Discovery Point Stage 1 Mixed Use Development - Response to Submissions

Project Application (MP 10_0030)

Discovery Place Stage 1 - Bio-filtration Tree Pit and Planters

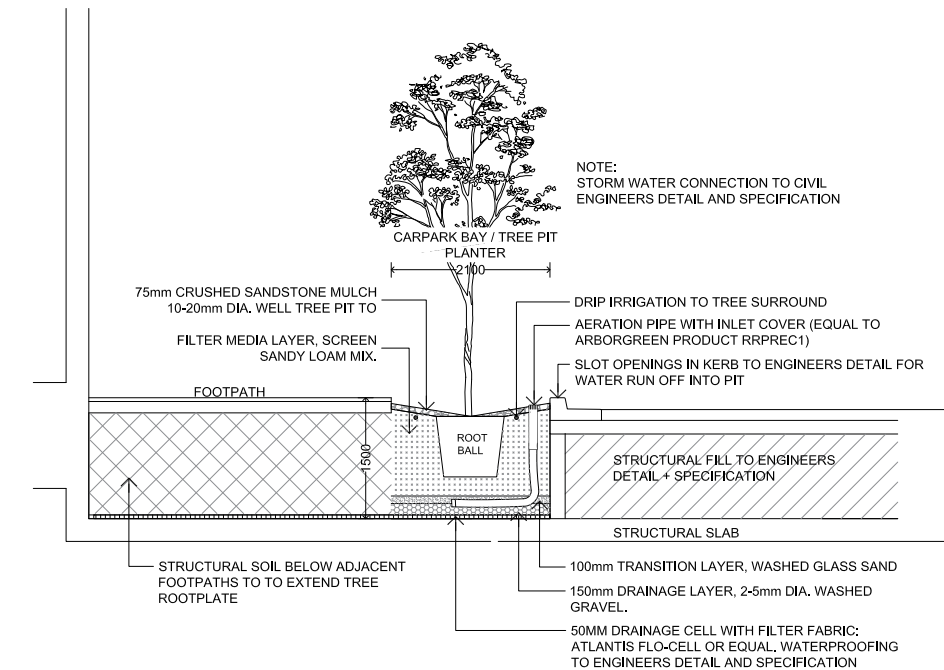
15.	The DGRs for Stage 1 required WSUD to be addressed and the Concept Plan approval contains condition 18(a), which reiterates the need for WSUD features to be used in the development. The application does not address water sensitive urban design, and	The incorporation of WSUD measures in the proposal have been investigated in detail. The WSUD strategy proposed for the Stage 1 works aim to improve and reduce storm water (SW) runoff rates from site. Features of the WSUD strategy include: Where possible all stormwater runoff from pedestrian pavements to fall towards planter areas to reduce run off rates and promote passive irrigation to planter areas.

3. Brodie Spark Drive and Discovery Place Corner Detail

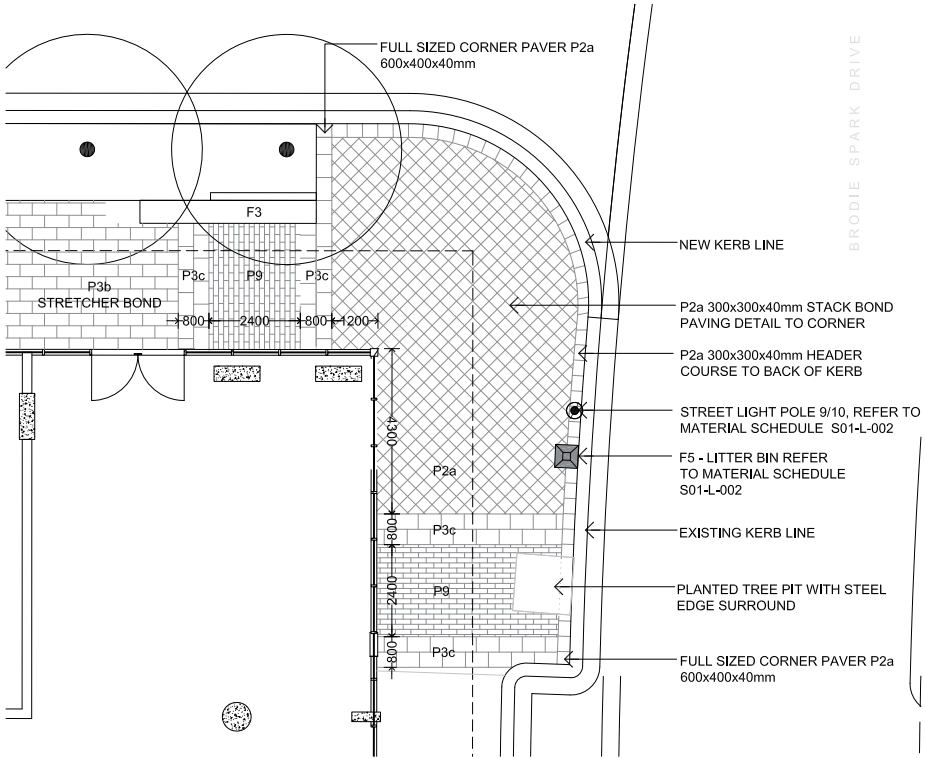
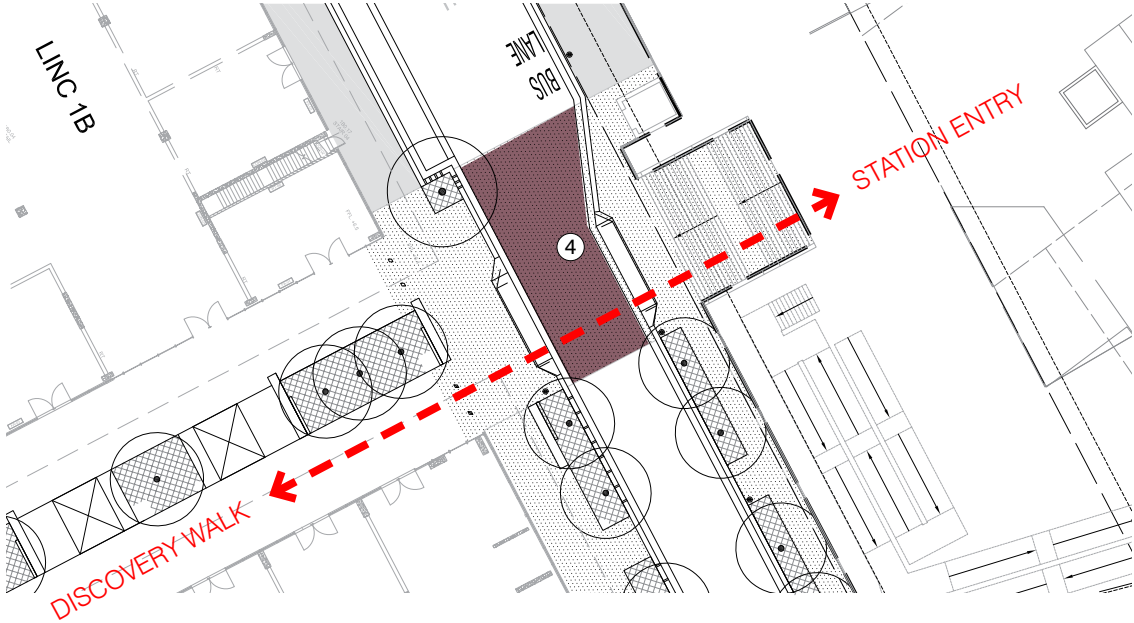
10.	Proposed landscaping and public domain works are to conform with the Wolli Creek and Bonar Precinct Public Domain Plan (PDP), particularly the Technical Manual as required by several conditions of the Masterplan consent. The email (Appendix S) does not constitute an agreement to modify the PDP.	Noted. Correspondence is to be provided to Council for endorsement outlining and justifying where variations to the Wolli Creek and Bonar Street Public Domain Plan and Technical Manual are proposed. A draft of the justification statement, prepared by Turf Design Studios, is provided for information purposes at Appendix D . In summary, despite the variations, the proposal is generally consistent with the Public Domain Plan and Technical Manual.
